6 September 2021

**SSD 9726 – ADAPTIVE REUSE OF THE ROYAL HALL OF INDUSTRIES
CONDITION B34 – HERITAGE INTERPRETATION
CONDITION B38 – HERITAGE – MINIMISING IMPACTS**

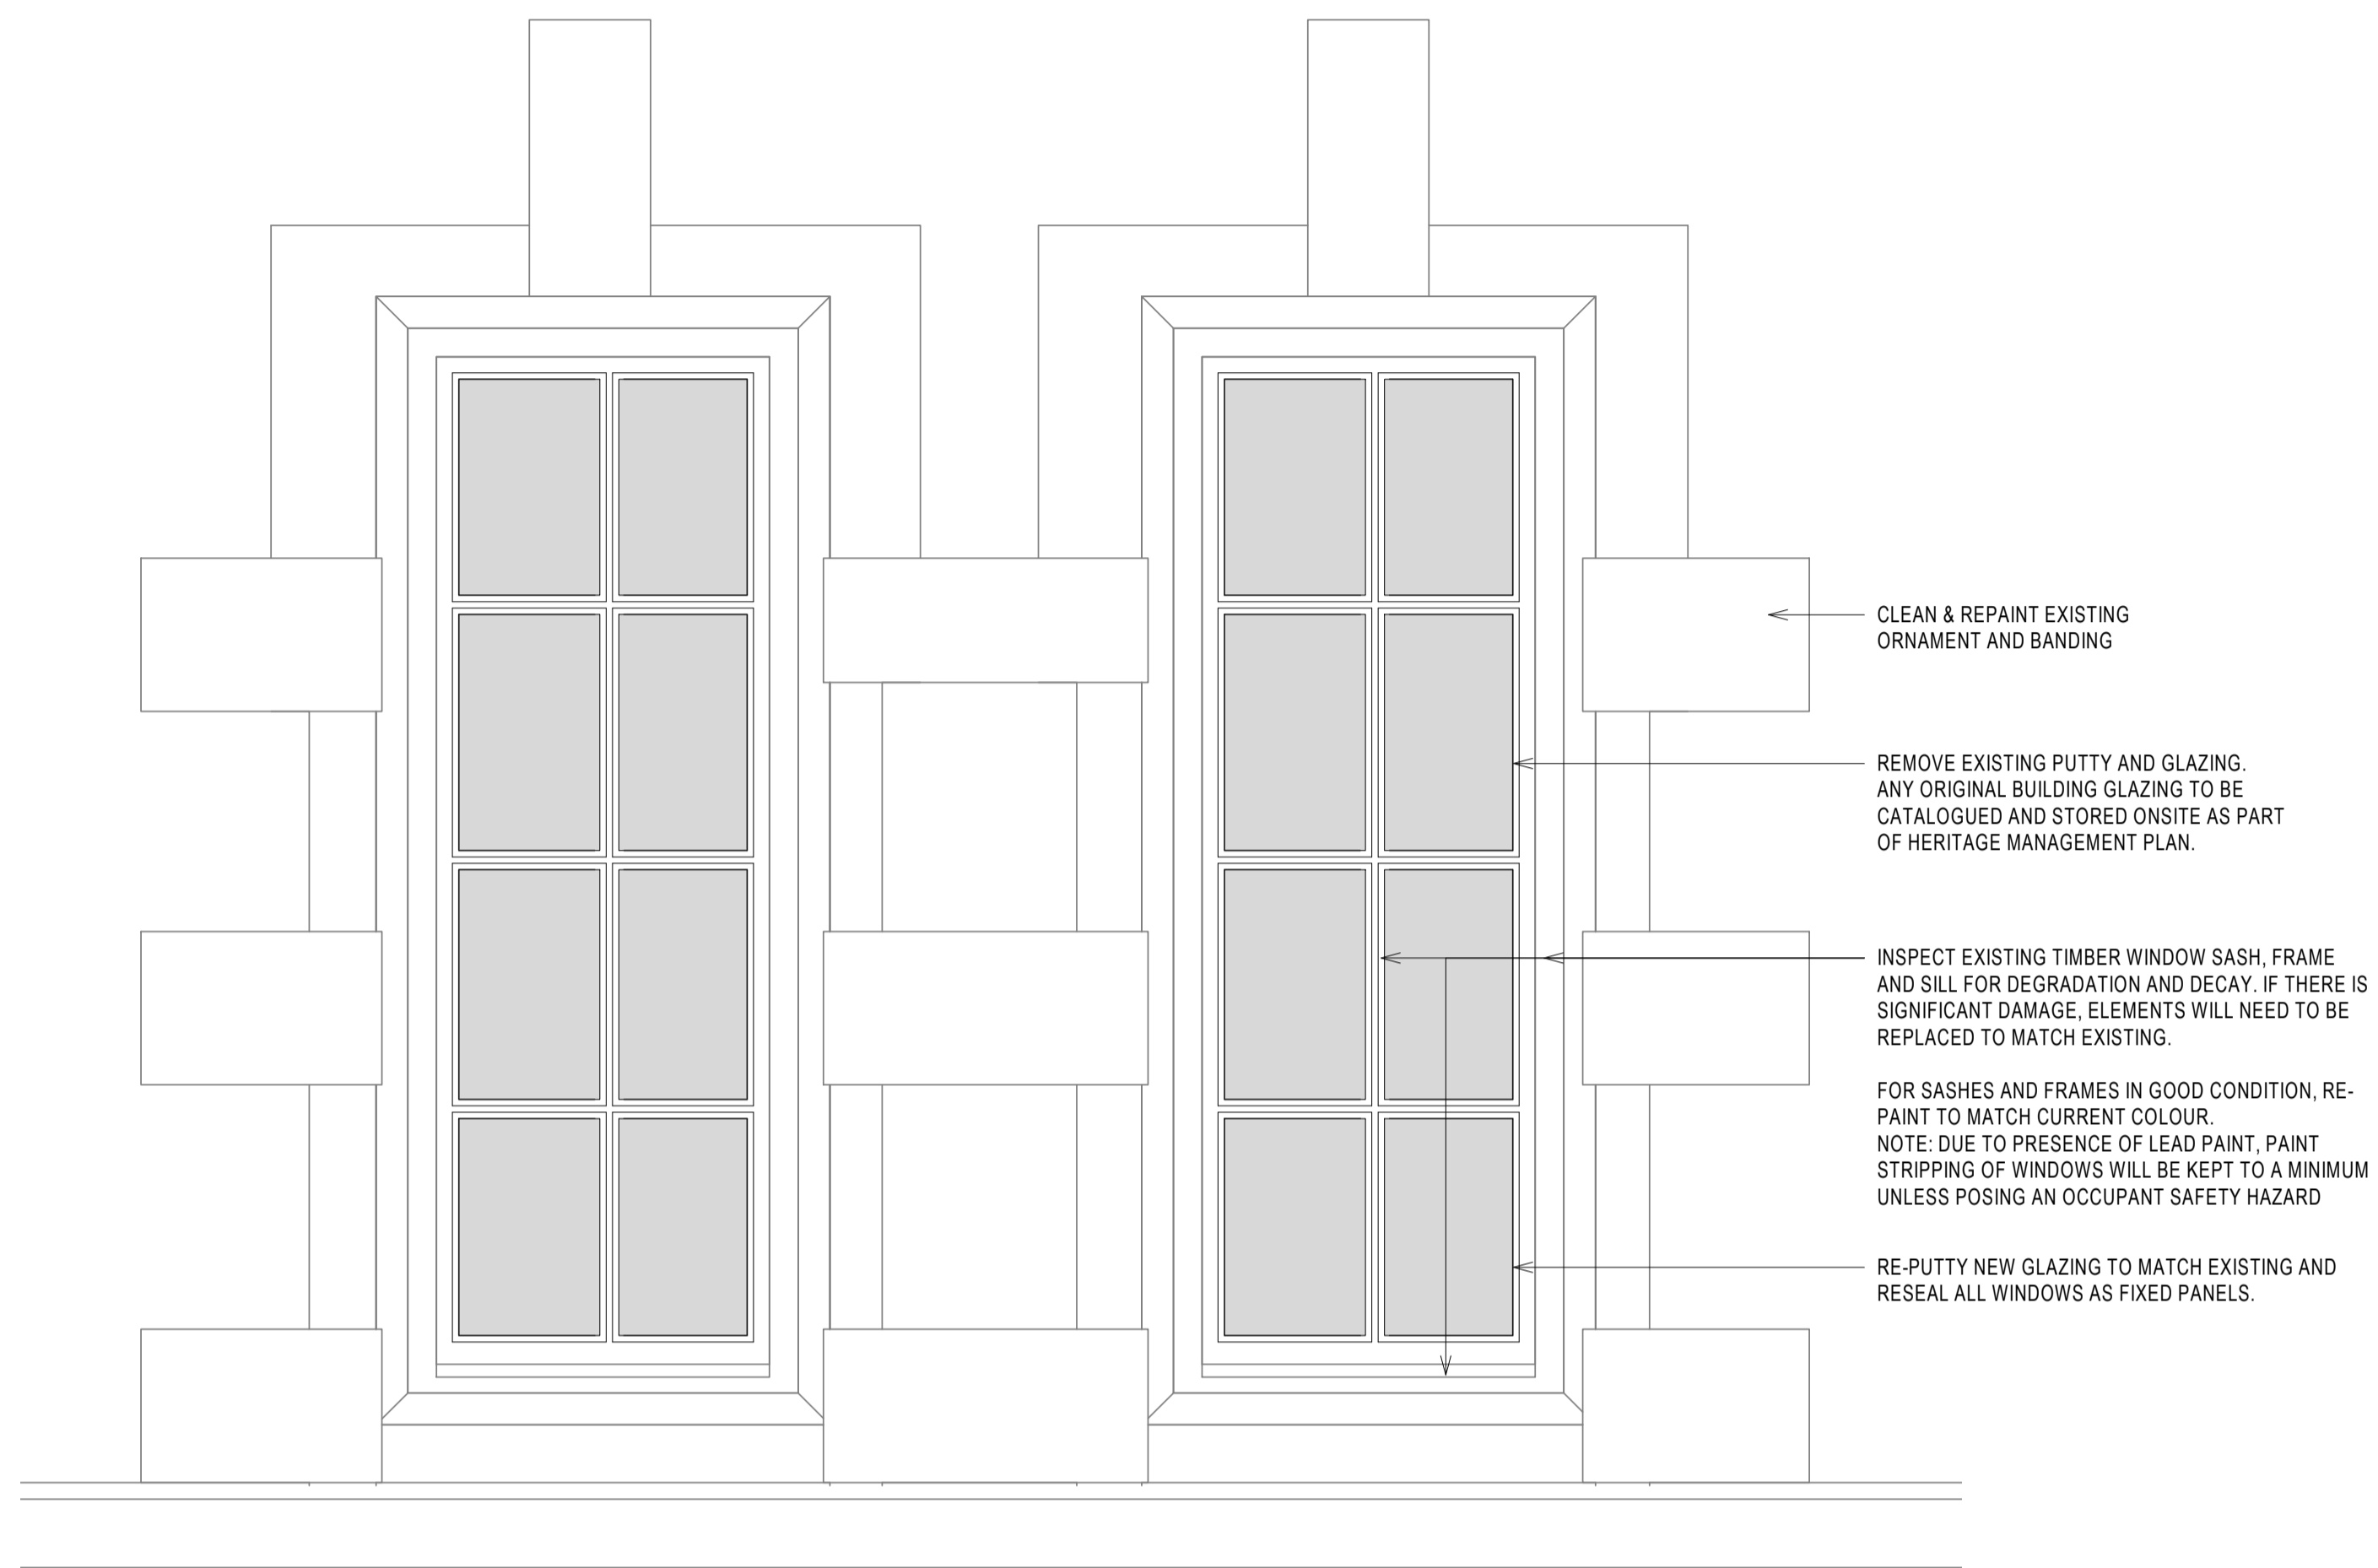
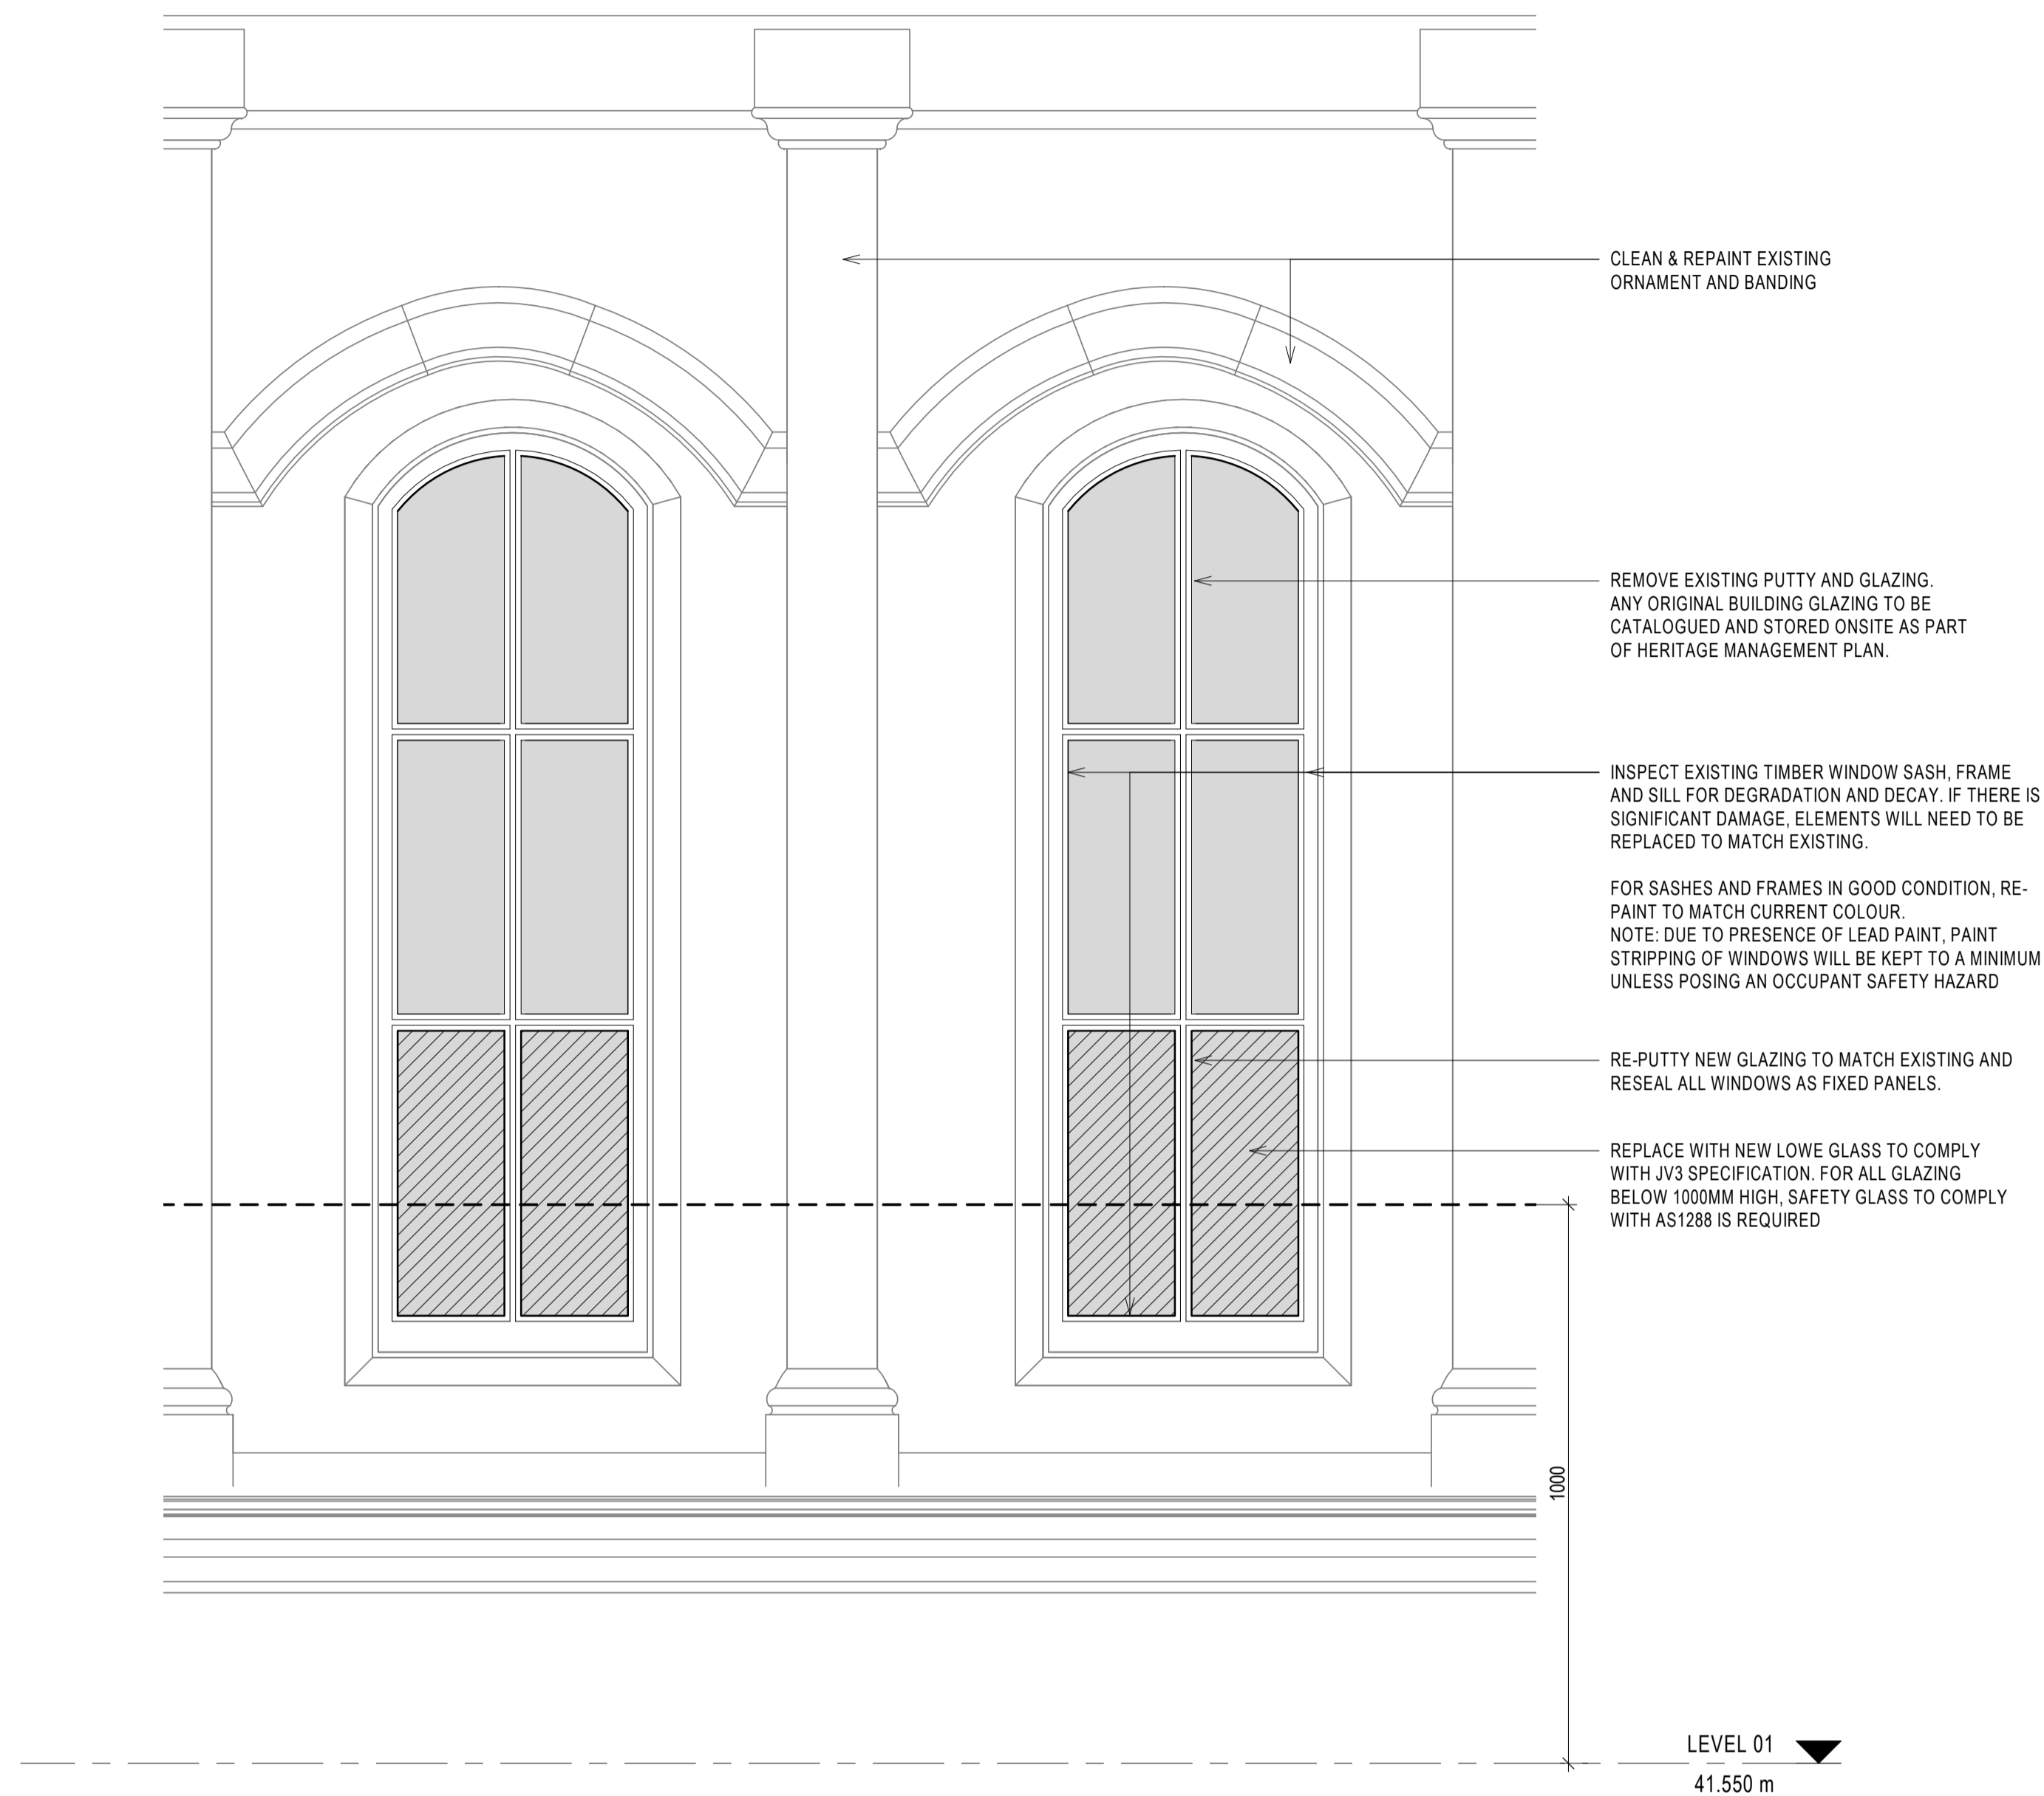
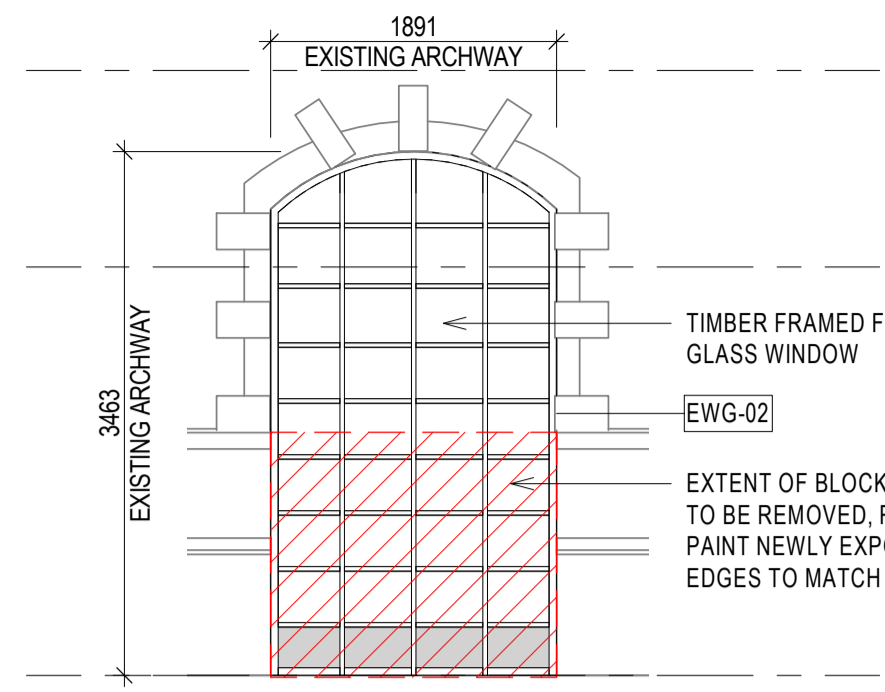
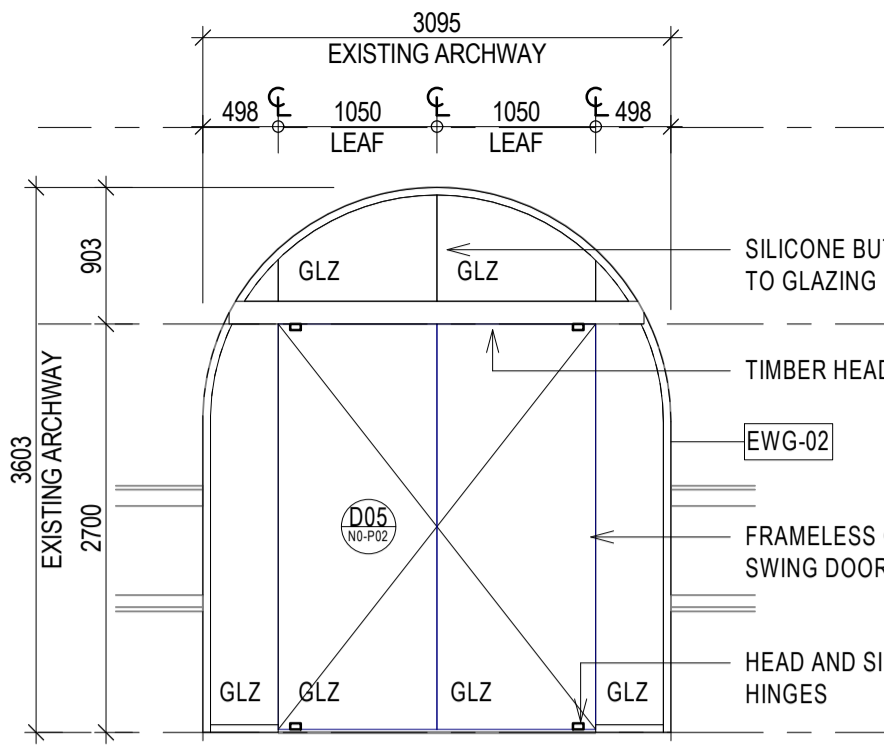
The submitted letter by Populous, dated 23 July 2021, and elevations and window details prepared by Populous, satisfactorily demonstrate how heritage impacts to existing windows and doorways will be minimised. Evidence of endorsement of this strategy by Heritage NSW is required by this condition.
